## Application for a Non-Material Amendment Following a Grant of Planning Permission

Demolition of outbuilding and erection of 1 no. detached dwelling at Land At Old Hill Sampford Road Radwinter CB10 2TL

UTT/19/1625/FUL

Additional photovoltaic panels on northern portion of flat roof and details of two airtsource heat pump locations on the east elevation.

PLANNING MAR 2019 1:200@A3 TS TS
01 AP(0)33 D

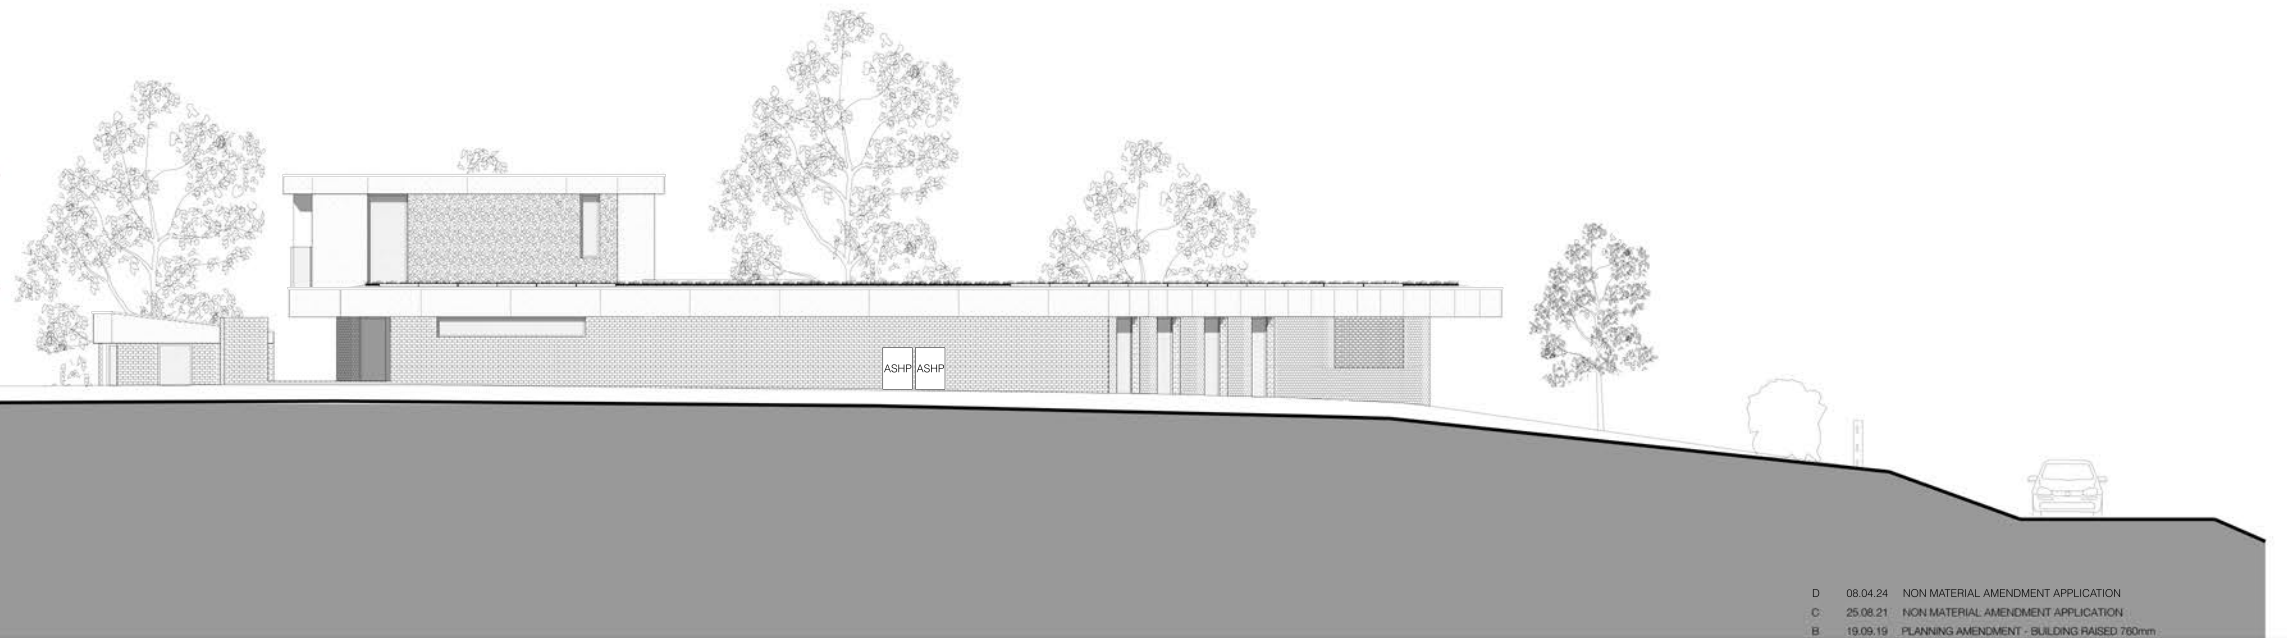
The location and size of the two ASHPs has now been reflected on the plans and elevations. The location on the east elevation has been chosen to minimise any perceived visual impact these may have. Again, this use of technology is being supported by Government planning directives and has a significant part to play in the UK's net zero target of 2050.
